DEVELOPMENT REVIEW BOARD
SUPPLEMENTAL SUBMITTAL

PROJECT NO. PR-2019-002184 (1001993)
Application No. SI-2019-00379

Memorandum

Re: Project Number: PR-2018-002184; Application Number: SI-2019-00379; Guardian Storage Site Plan-DRB Responses to Staff Comments

SITE PLAN - DRB

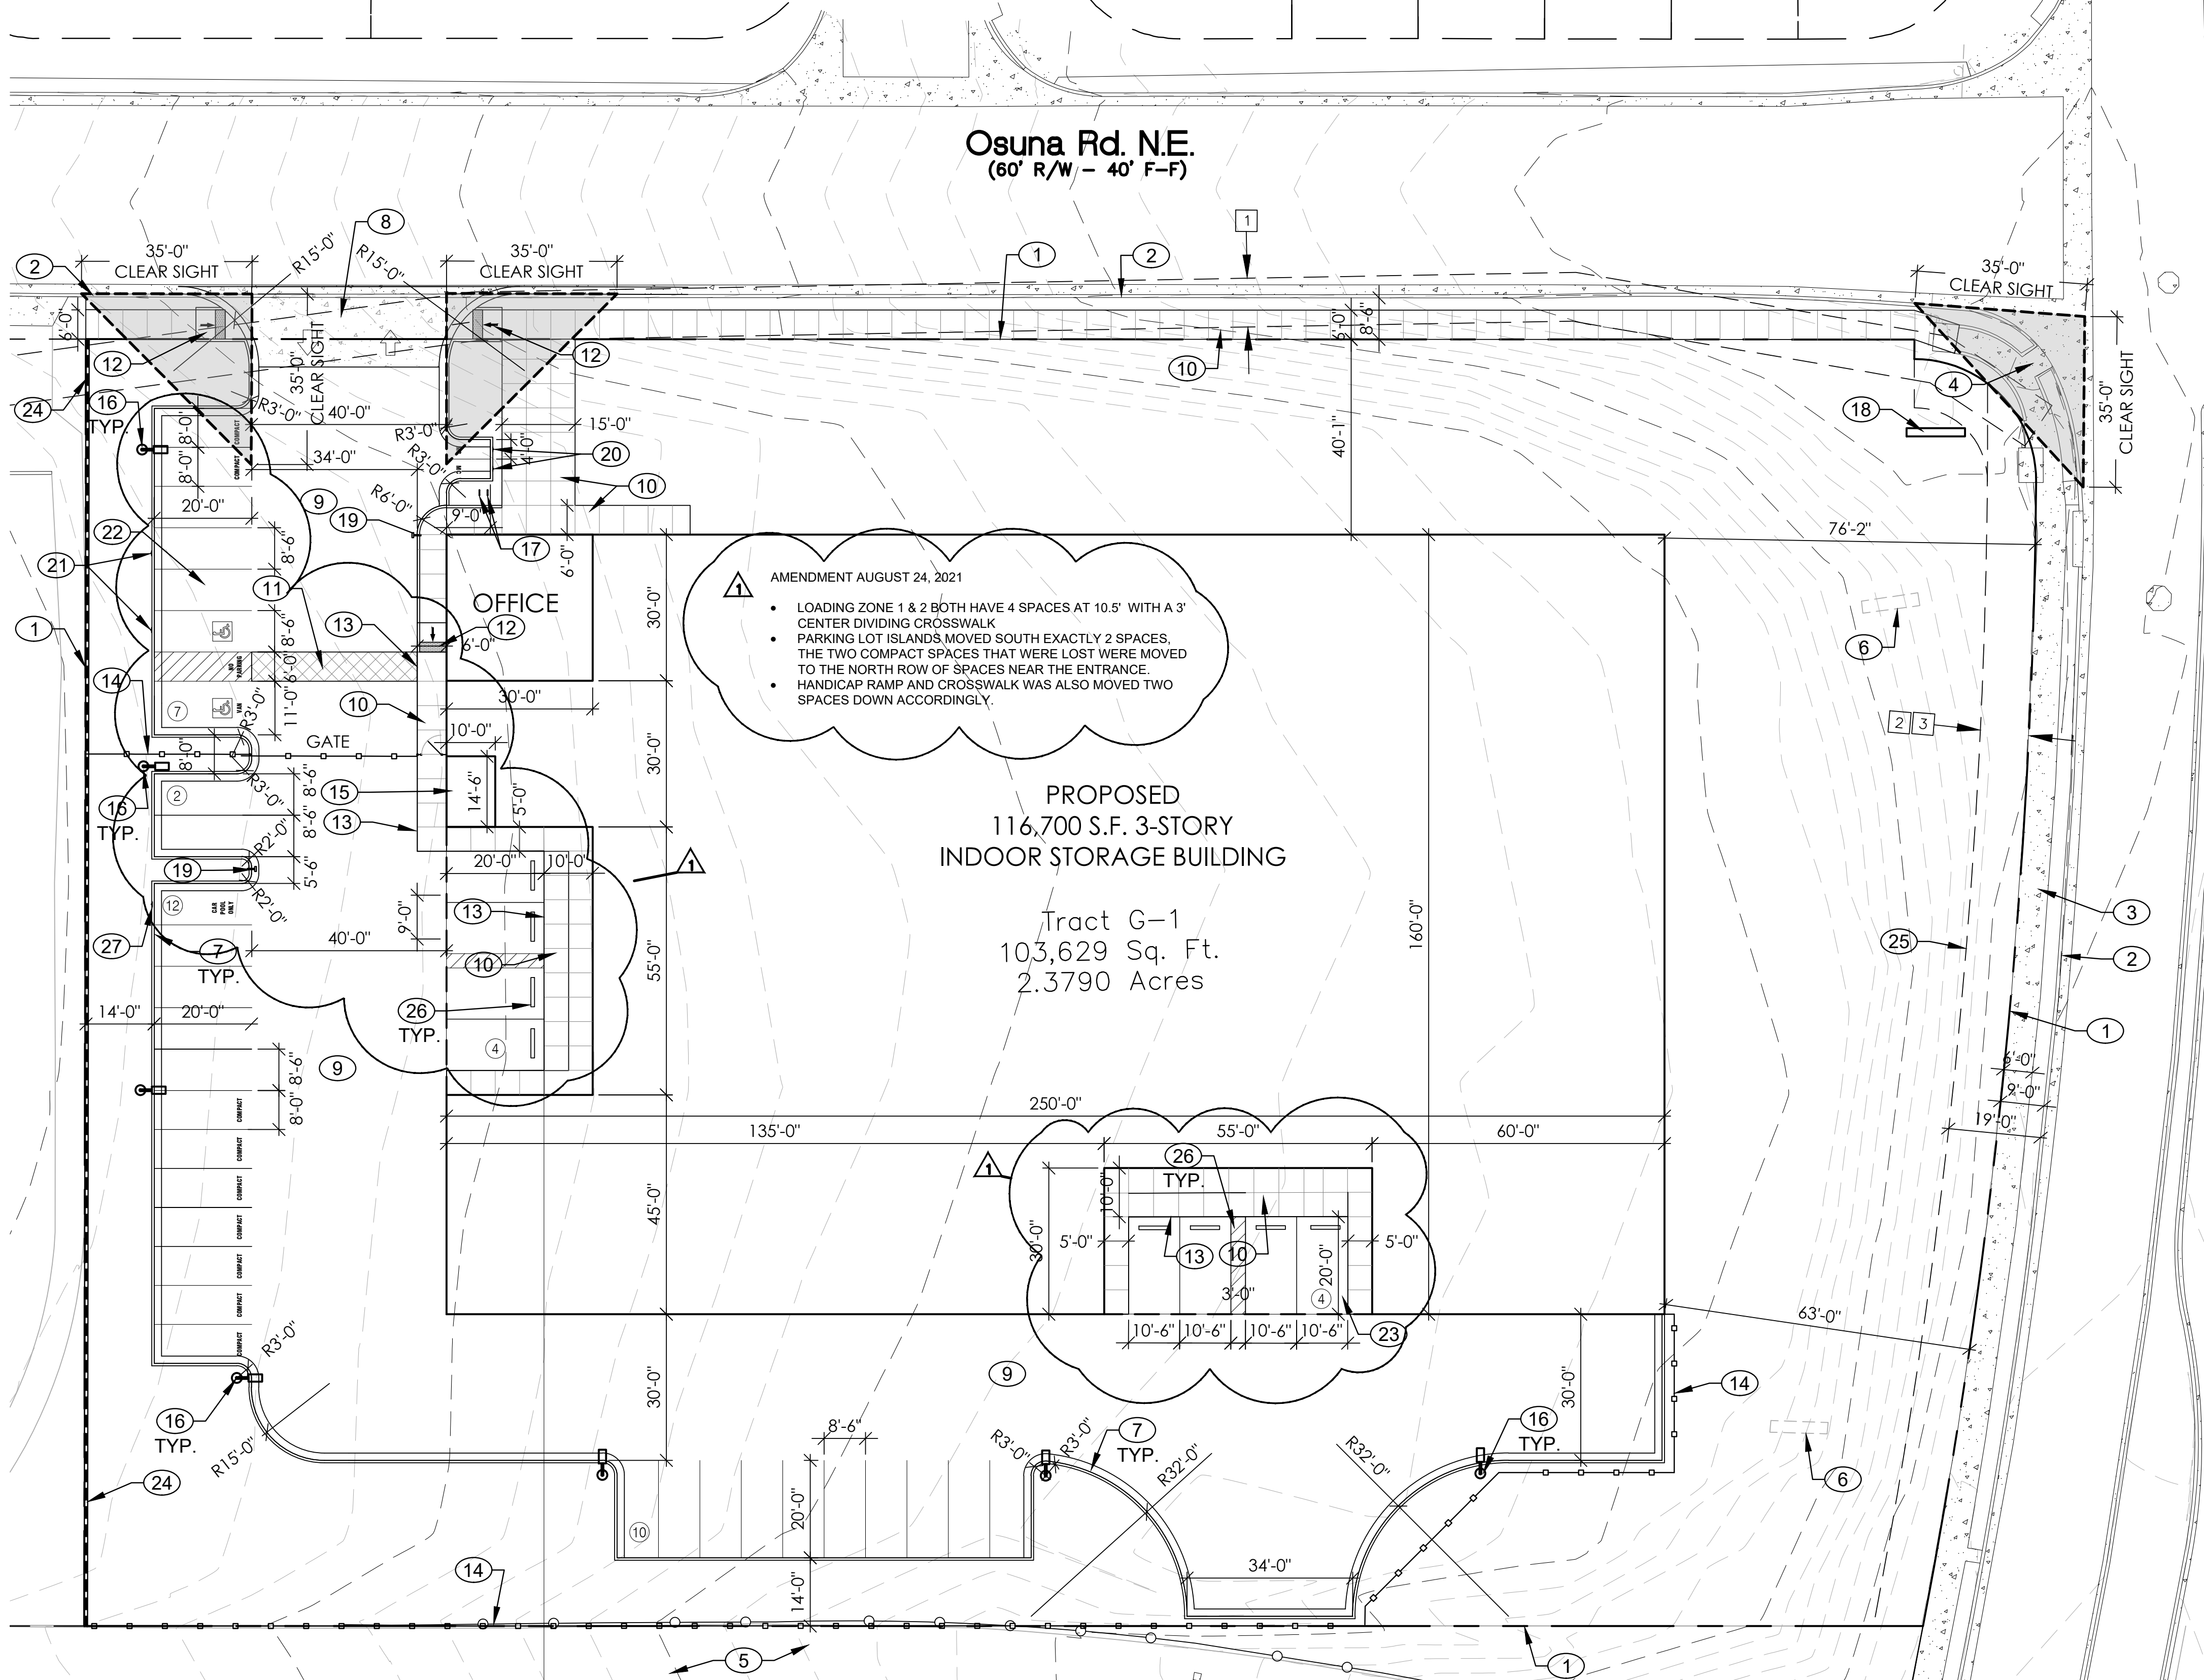
4. *No loading spaces are proposed, and 3 loading spaces are required.*

7. *See 5-3-(D)(3)(b) network of walkways for required walkways- the walkways provided are too narrow.*

To meet this requirement, the site plan has been reconfigured to add one 9 ft. x 25 ft. loading space to the loading area on the south side of the building. The Applicant

Applicant Response: The walkway on the north side of the building (facing Osuna Road), at the only pedestrian entrance to the building, has been widened to 15-feet, per *IDO Section 5-3(D)(3)(d)*.

SHEET TITLE: CONCEPTUAL DRAINAGE PLAN

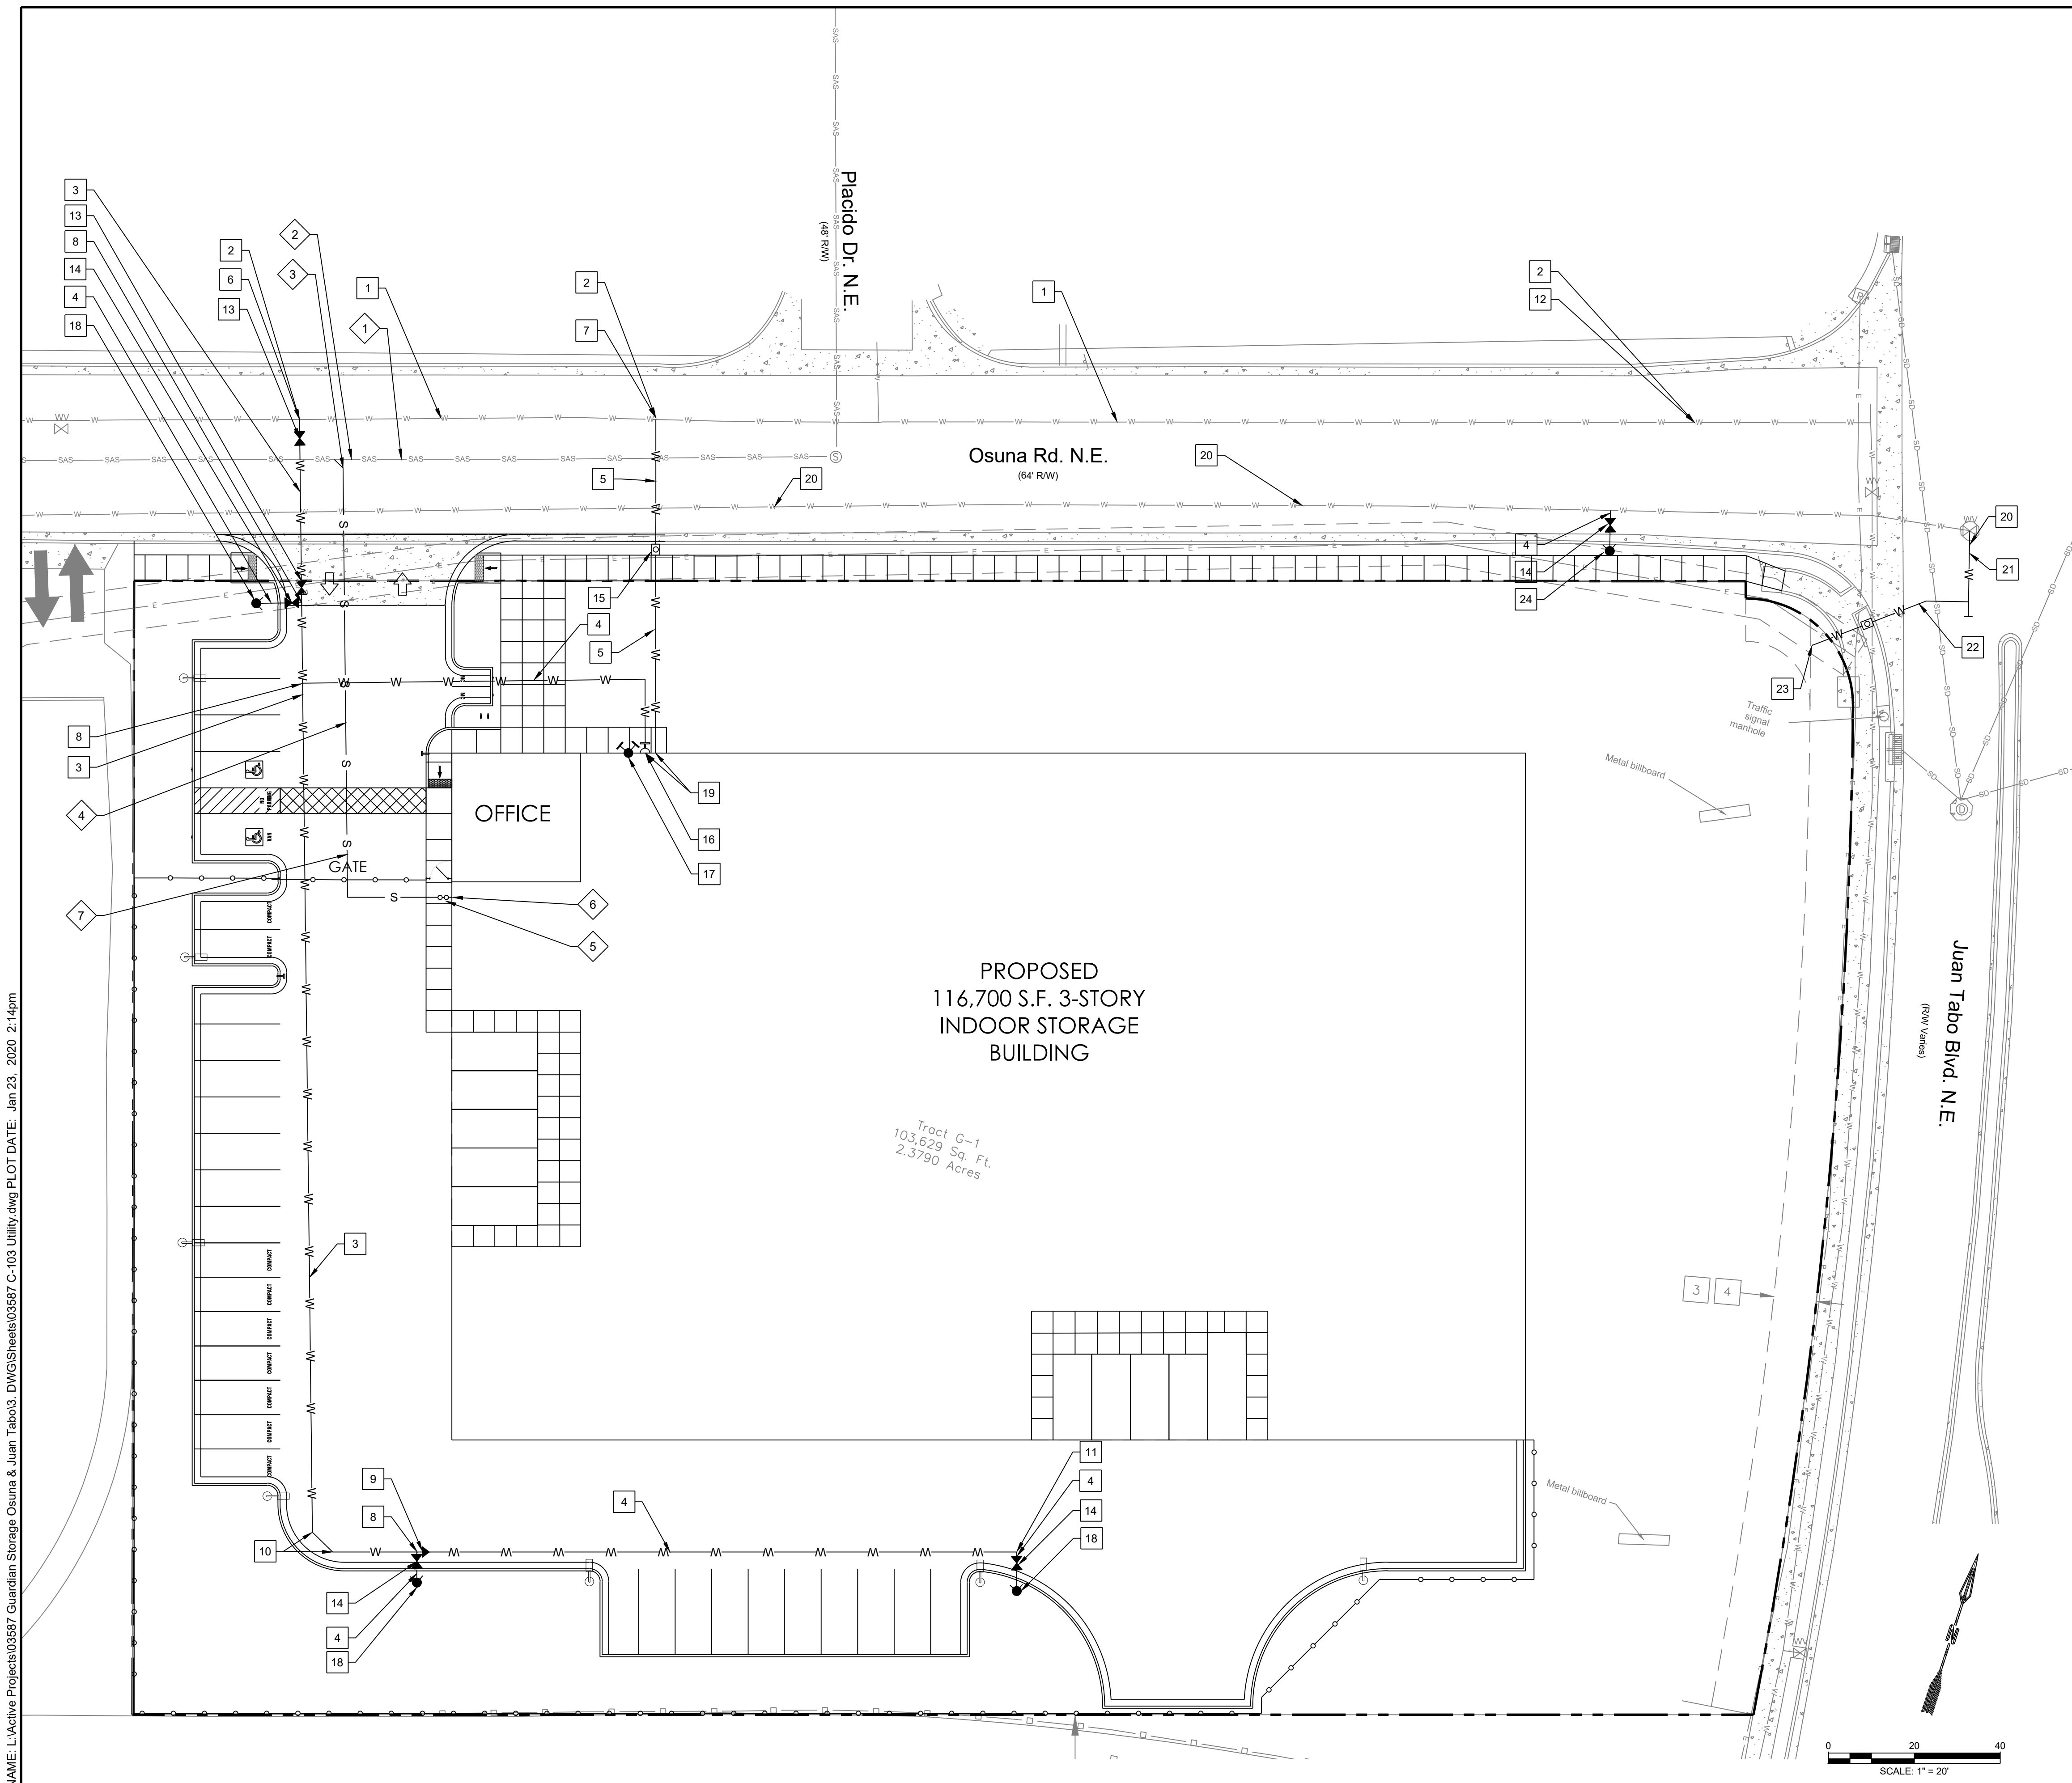
15. *Please provide elevations or a horizontal profile to illustrate the steep slopes.*

Applicant response: Elevations illustrating steep slopes are provided in the revised Grading and Drainage Plan. Additionally, a Street Elevation Study exhibit was submitted with the original application which shows the building elevation and slope along Juan Tabo Boulevard and Osuna Road.

SHEET TITLE: **CONCEPTUAL UTILITY PLAN**

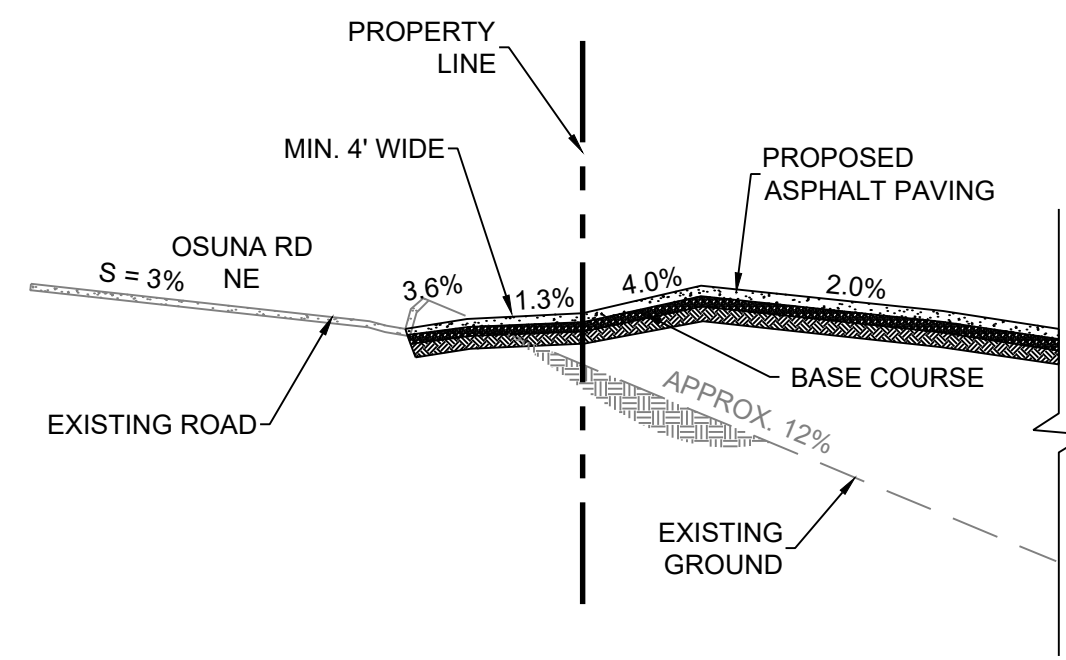
17. *Water Authority comment at December 18, 2019 hearing: There are non-potable lines on the property that can be used for irrigation.*

Applicant response: The 33 PSI available from the water reuse line will not be sufficient pressure for the proposed irrigation system. Irrigation bubblers typically require a minimum of 30 PSI at each head to operate properly and the entire system will require a minimum of 50 PSI at the point of connection. To be able to use the water reuse line a booster pump will need to be install the irrigation system which would add considerable

cost to the system. The Utility Plan shows 1 meter coming off the potable water line. The Water Authority will be testing the pressure of the line for verification. The Utility Plans will be updated if it is determined the pressure is adequate for site irrigation.
